CITY OF ALBUQUERQUE

August 19, 2016

RE: **KINESIO Headquarters**
4001 Masthead St. NE
Requested for 30-day Temporary C. O. - Accepted
Engineers Stamp Date 2/5/16 (D17D103)
Certification dated: 8-15-16

1 | grading and drainage plan  
 1"=20'  
 0 10' 20' 40' 60'

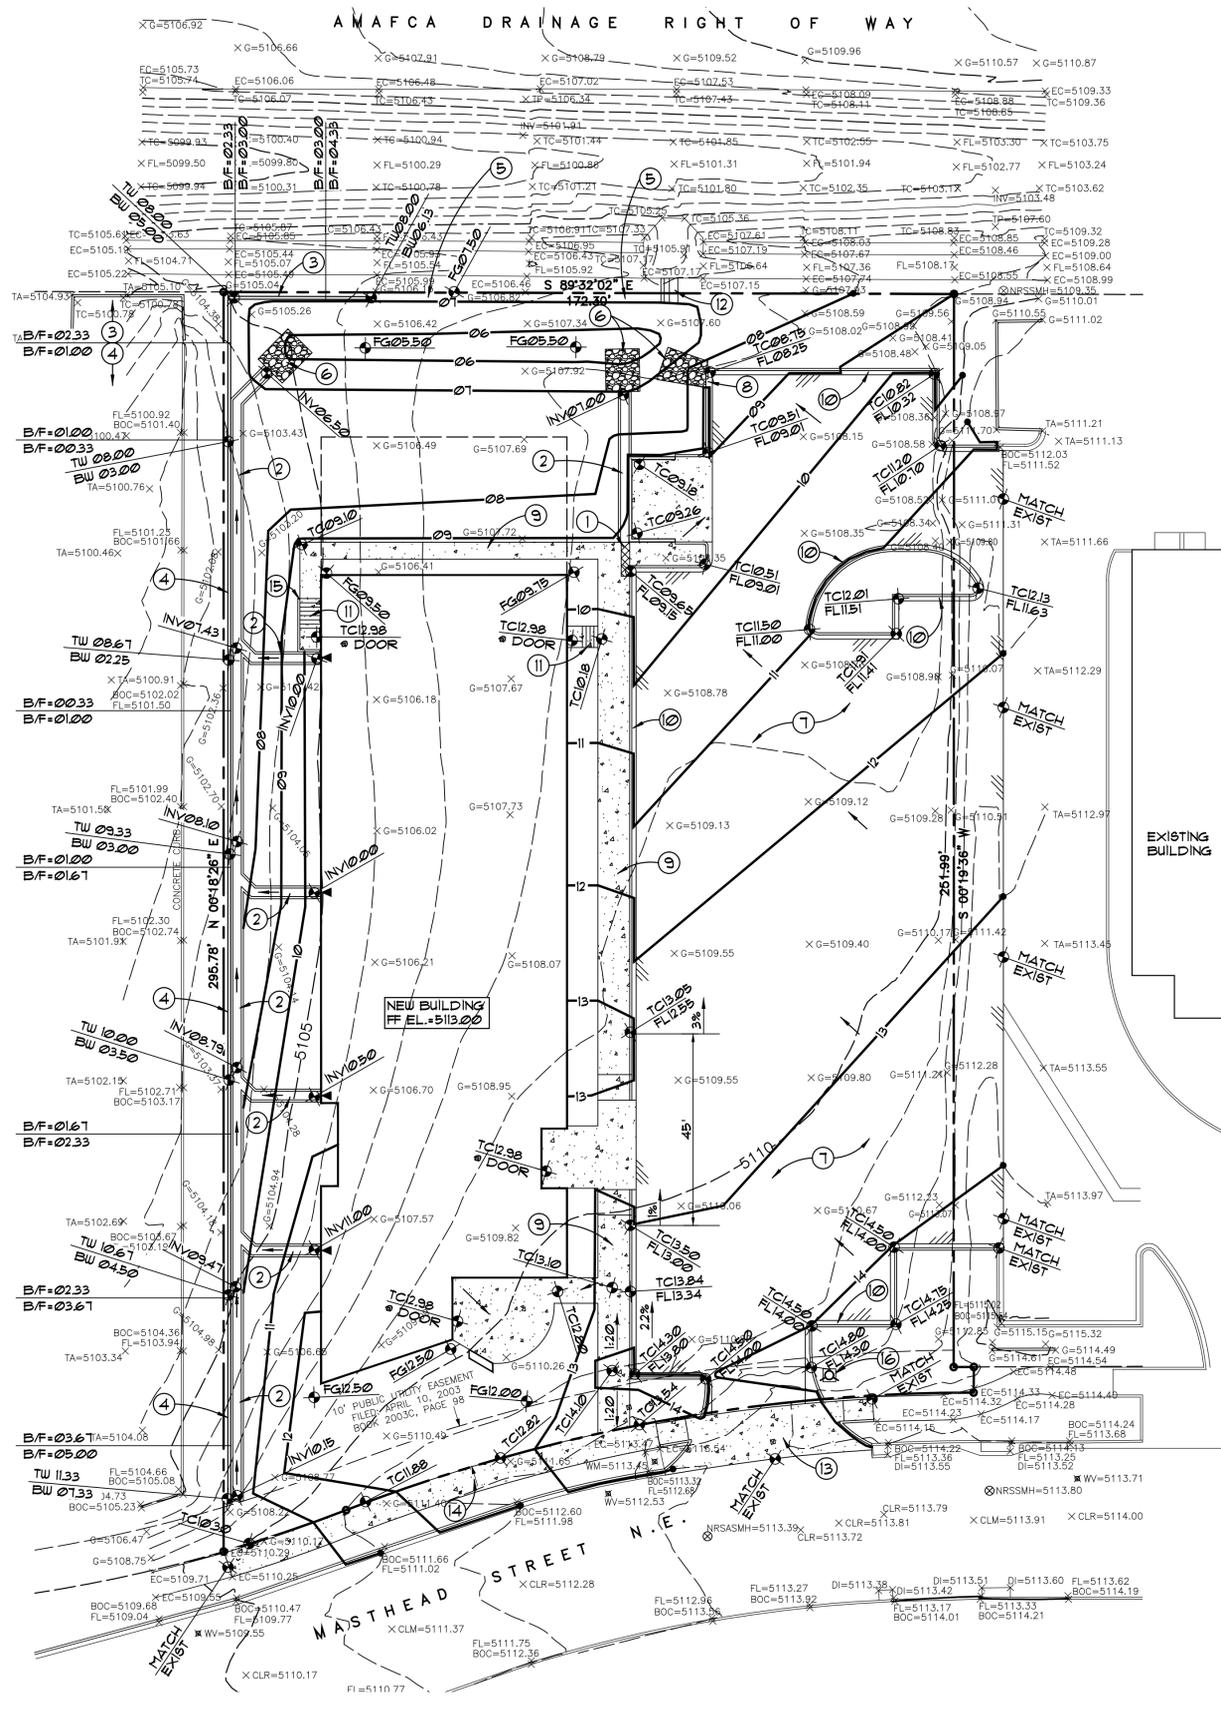
- The swale that fronts the property needs to be put in place.
- The transition between this property and the adjacent property to the west should be revised. The swaddle should be moved to the adjacent property. In its place fractured rock should be placed so any spillage from the 2' concrete rundown will overflow on top of the fractured rock prior to draining on to the swaddle.
